**From:** Daniel Puzak <daniel@ariascinc.com>  
**Sent:** Friday, May 05, 2017 1:07 PM  
**To:** Cloud, Jack W.  
**Cc:** Debra West  
**Subject:** Re: 5701 Wilshire NE Site Plan

We are working on a small addition and some landscape improvements to the above listed address. I have attached what is on file for the site and what we have submitted for permit. Concetta is requesting we submit an AA on the site plan. Would you have some time to discuss this prior to us submitting the AA? Are you available this afternoon or tomorrow morning sometime?

LANDSCAPE AND Site Plan

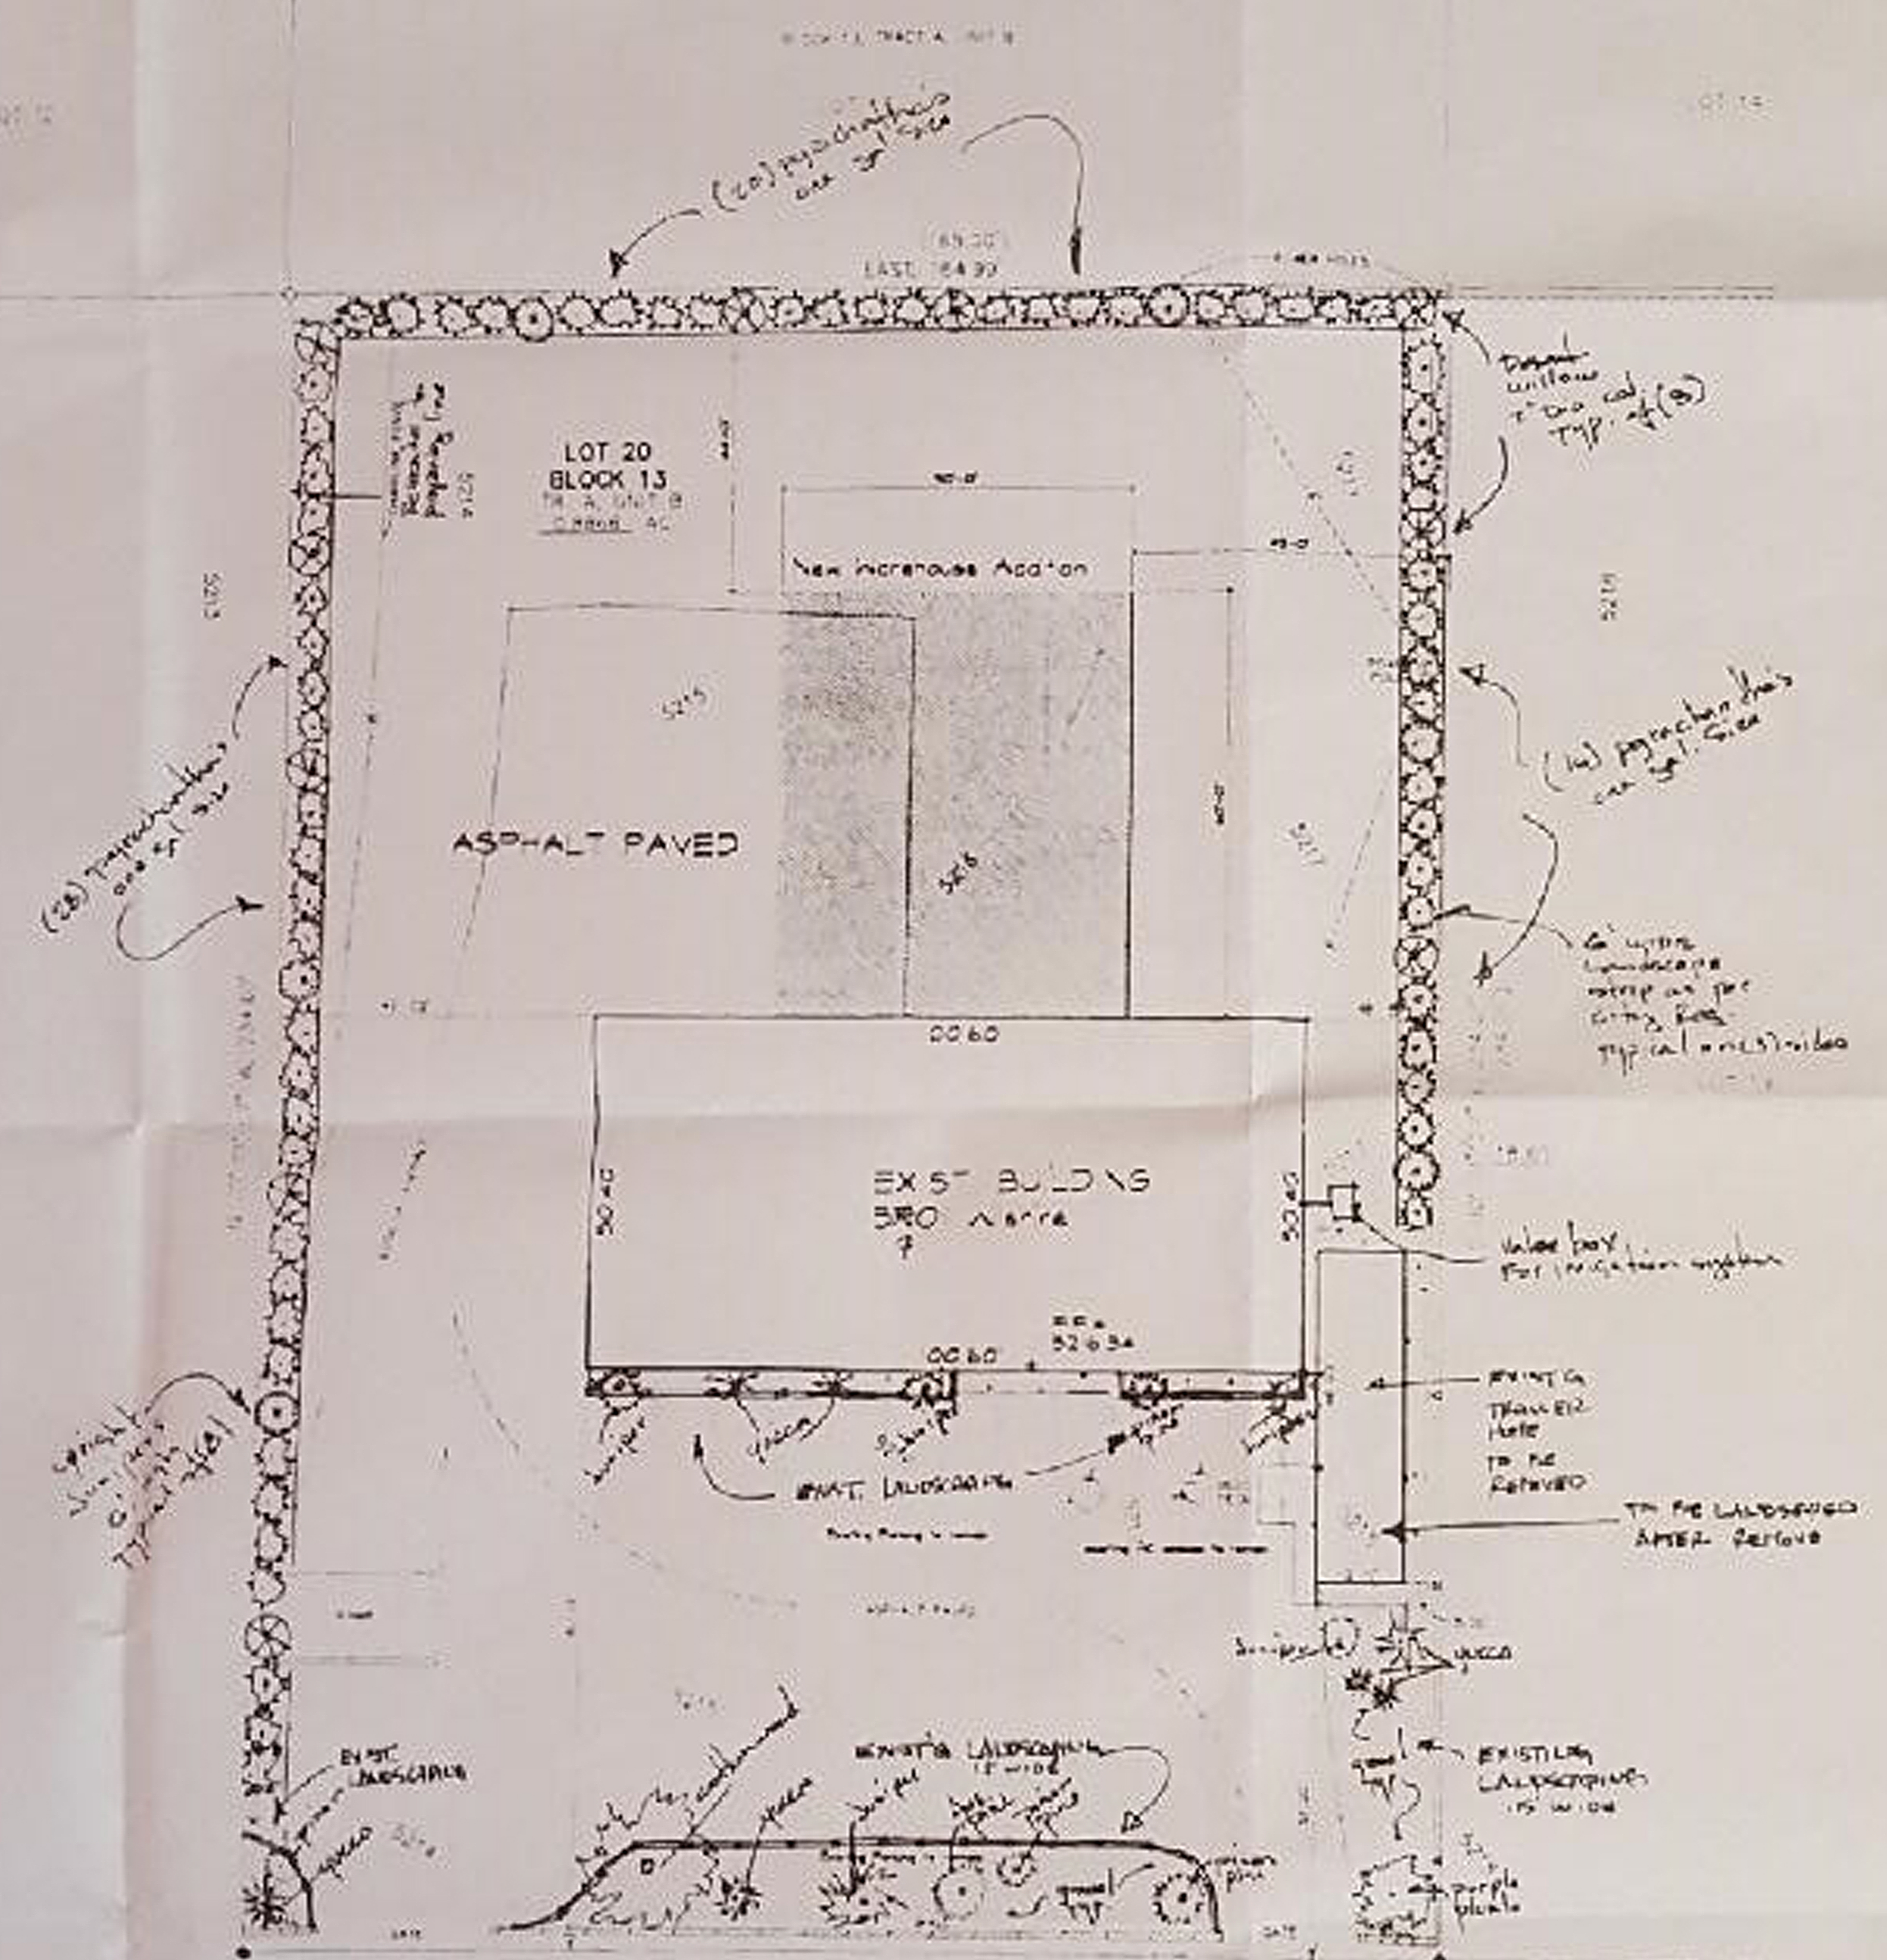
With some revisions for the landscaping I would approve an Administrative Amendment for 5701 Wilshire NE. I've got a mark-up of your plan here – basically just provide a little more variety/ placement in the planter outside the wall and update the plant list.

I could meet tomorrow morning at 11:00, after DRB. Based on the attachment it appears you will need a variance to the current landscape requirements of the Zoning Code, particularly regarding required landscape buffers.
